NORWICH TO TILBURY

EN020027

Comments on Submissions received at Deadline 1

Suffolk County Council [REDACTED]

Revision:
C

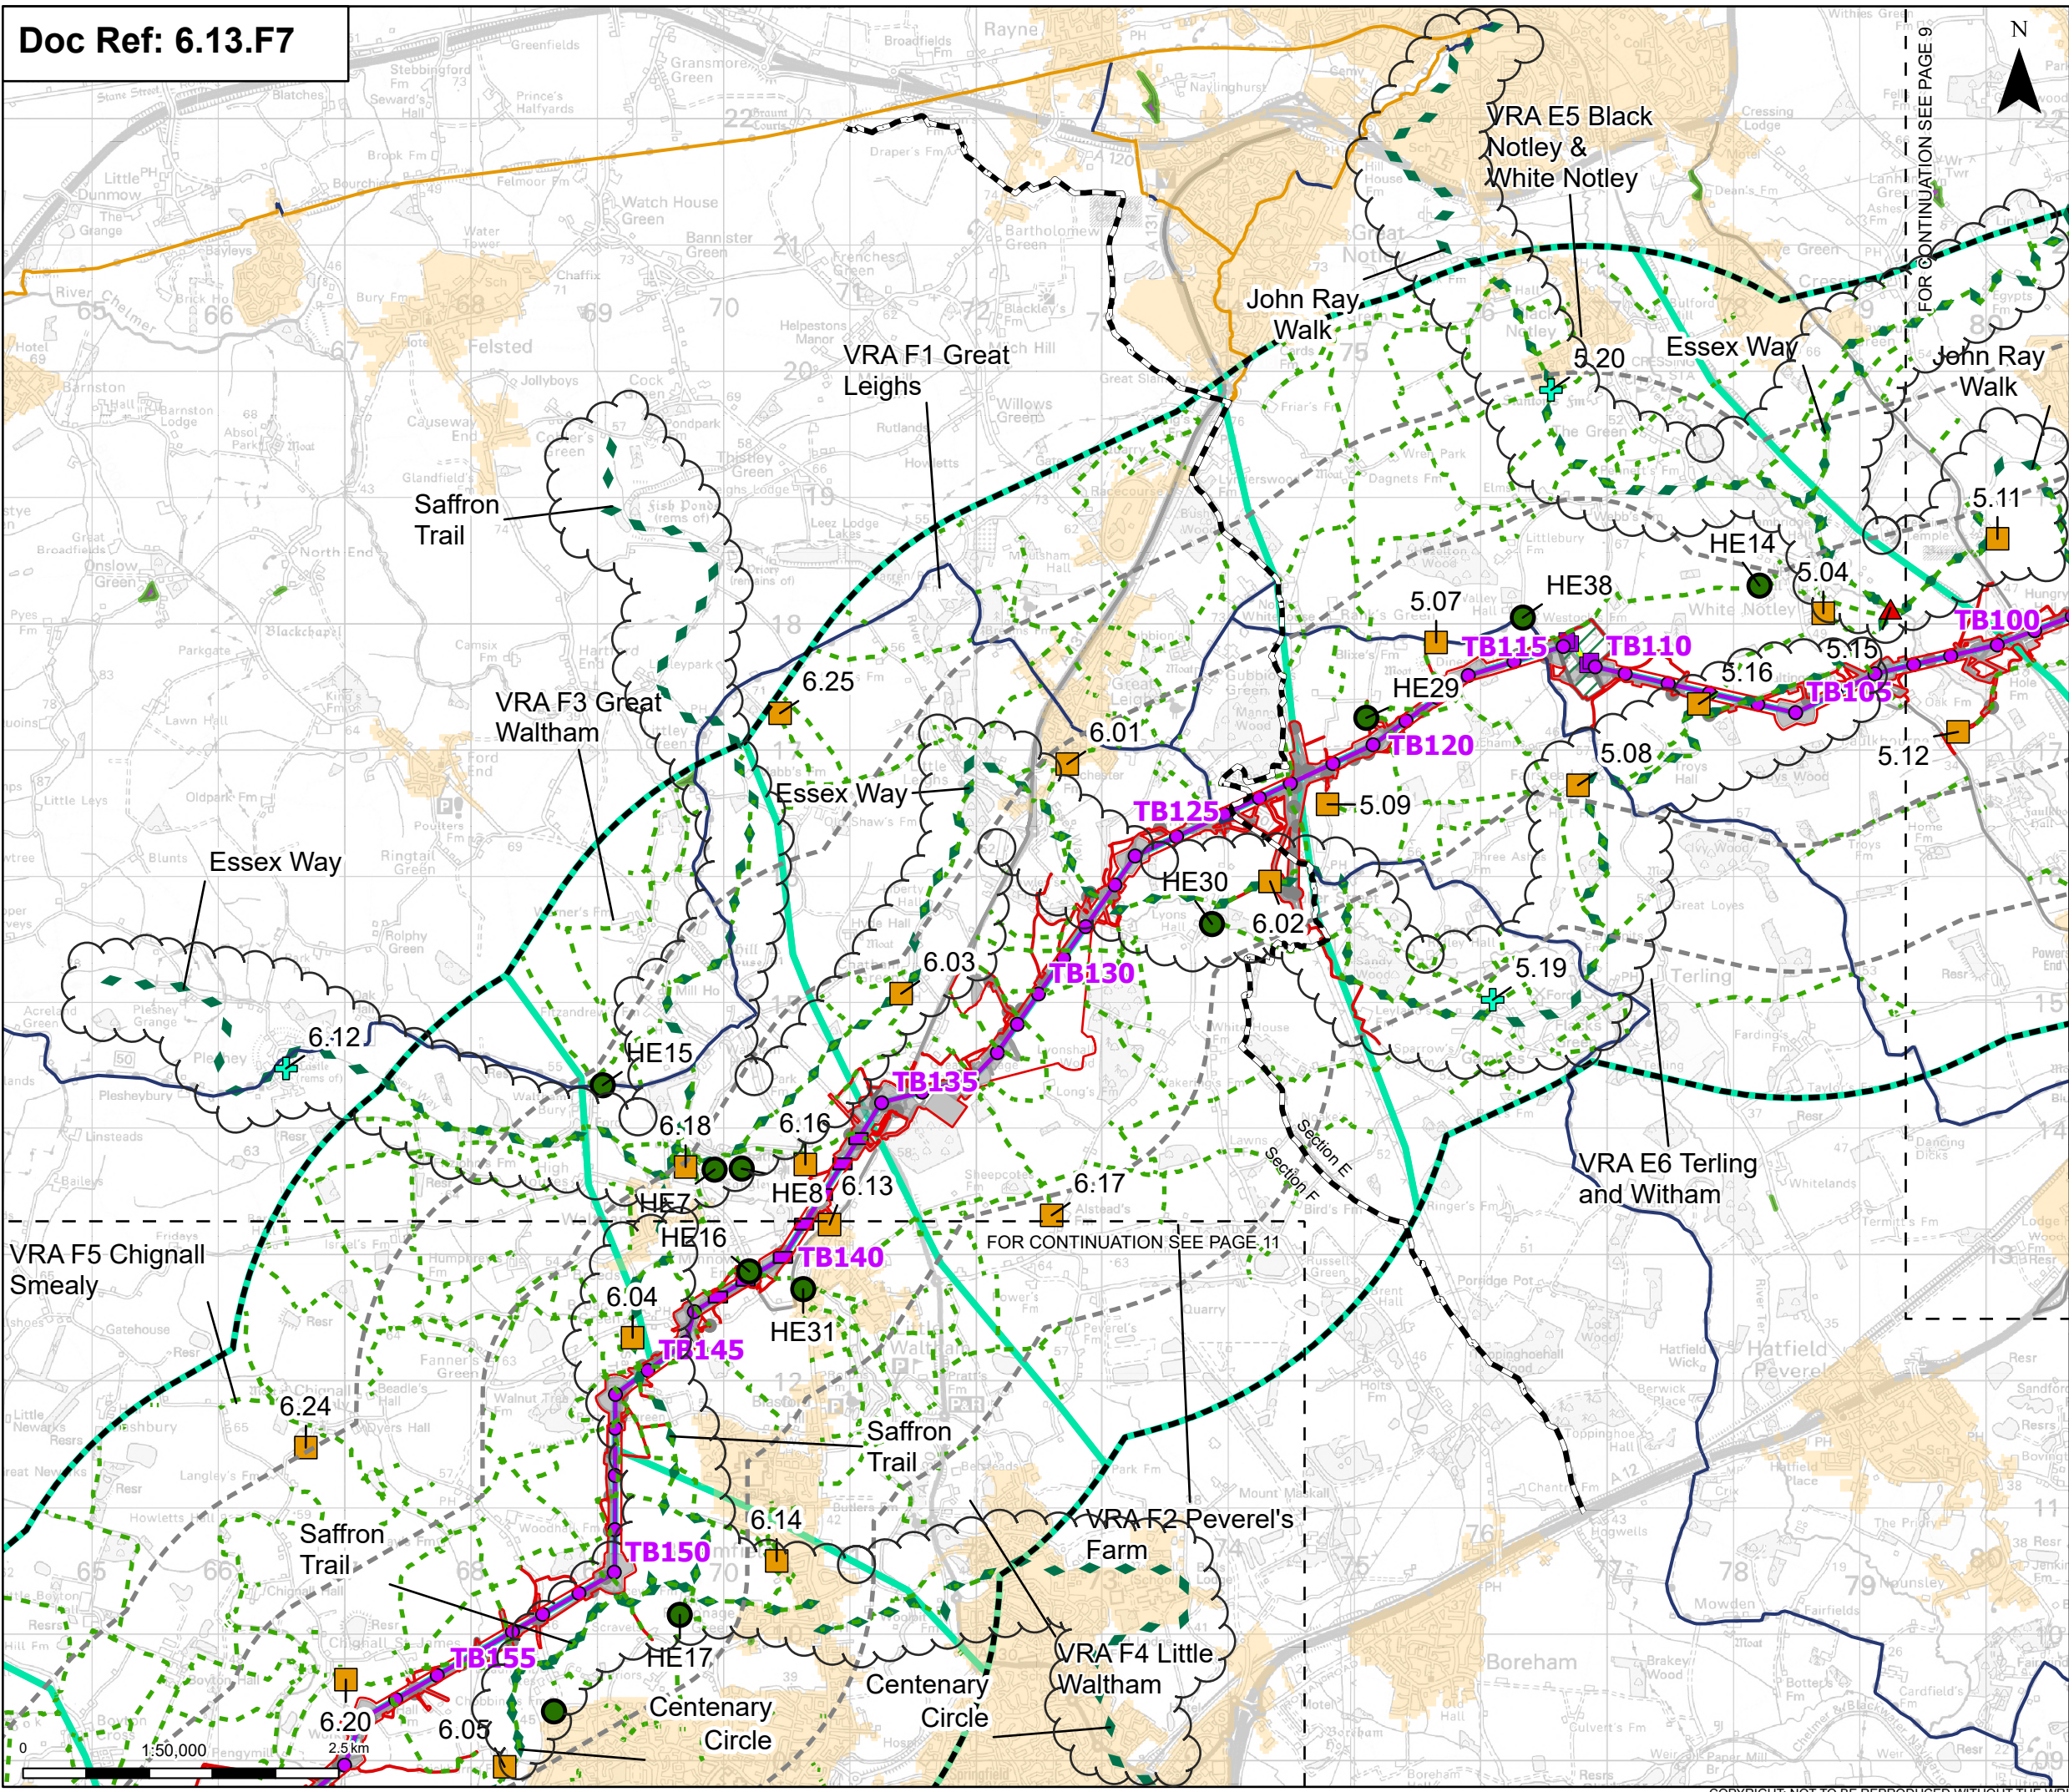
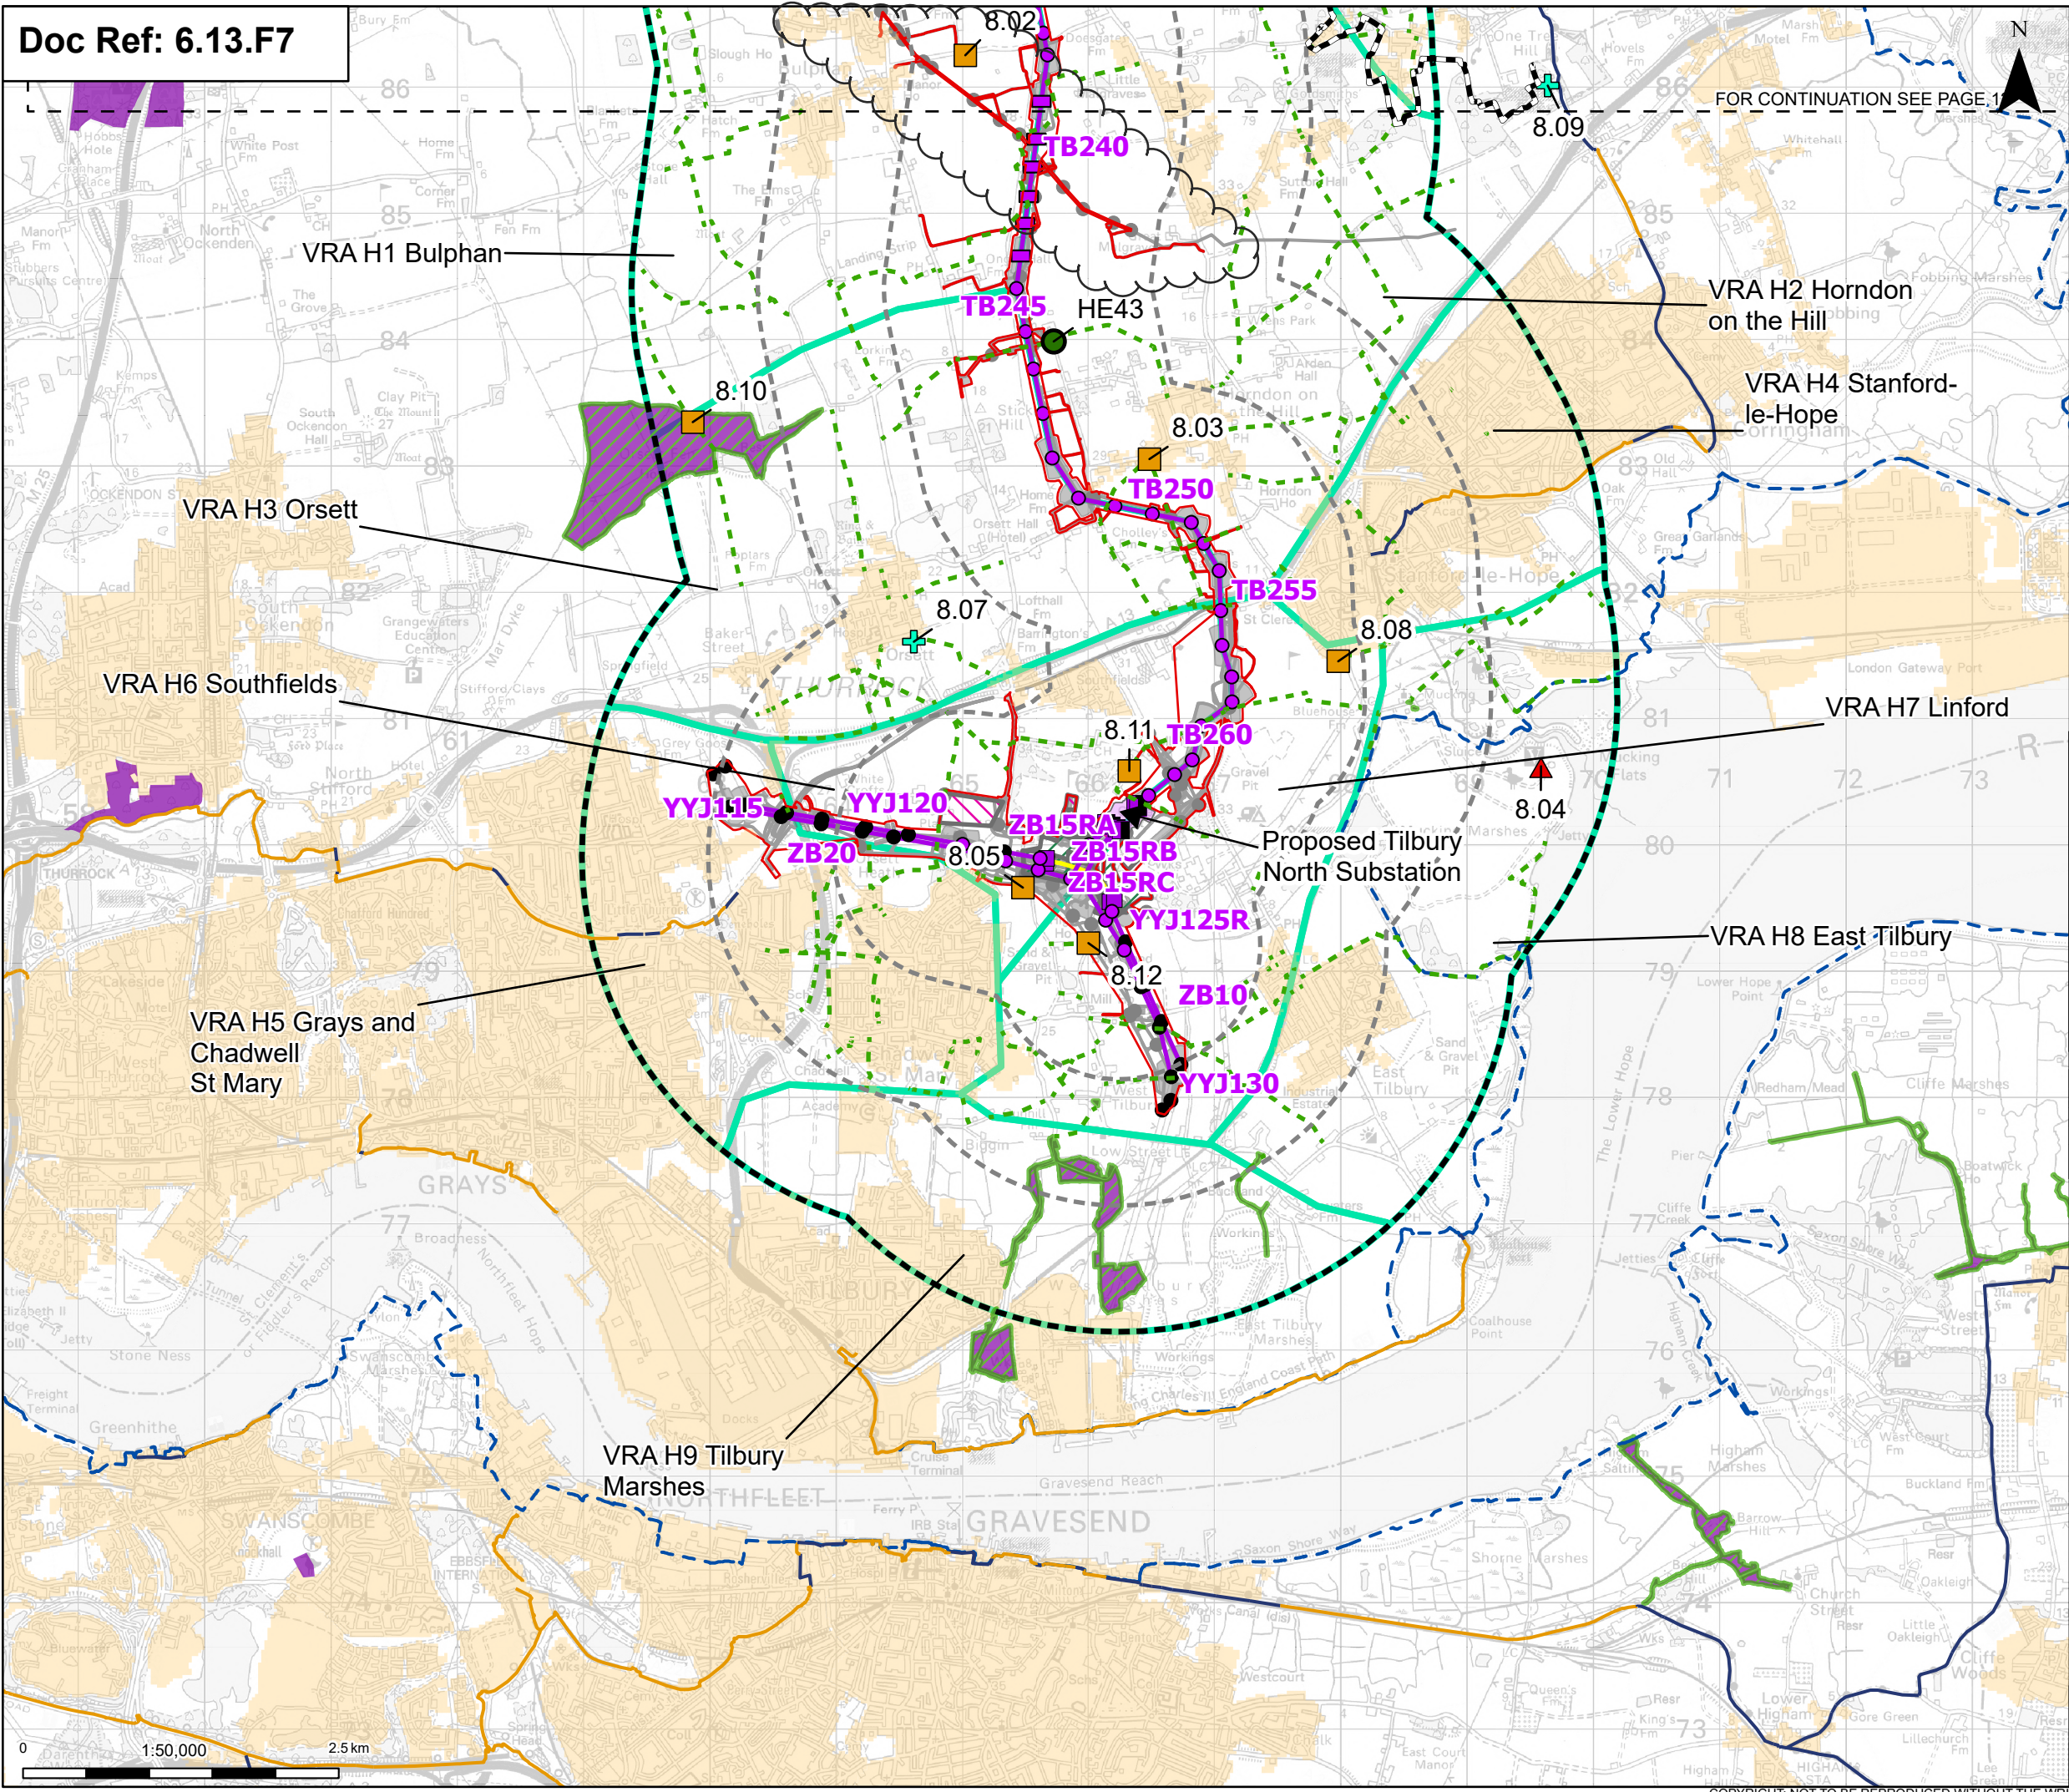
3.2	Errata	<p>Table 1.1 (6.13.F7) Environmental Statement Figure 13.7: Visual Receptors and Viewpoints</p>	<p>SCC would welcome, if the Applicant was to confirm that this was the only change between the two versions. Alternatively, if other additional changes have been made, SCC considers that the</p>	<p>[APP-243] [REP1-071]</p>

<p><i>“Incorrect revision uploaded in error with application - long distance footpaths were not included on the Figure.”</i></p> <p><i>“Figure 13.7: Visual Receptors and Viewpoints [APP-243] has been updated and is replaced by Figure 13.7: Visual Receptors and Viewpoints (Rev B) in Appendix A of this Errata.”</i></p>	<p>Applicant should clearly list what they are and on which sheets of the figure they can be found.</p> <p>No explanation is given as to the changes that have been made in Revision B versus Revision A [APP-243]. A page at the beginning of the document, that identifies the changes made, would have been helpful for any reviewer of the documents.</p> <p>SCC would consider it helpful if the Case Team were to update the Examination Library to include a note at [APP-243] to say that Figure 13.7 is superseded by [REP1-066].</p>	
--	--	--	--	--
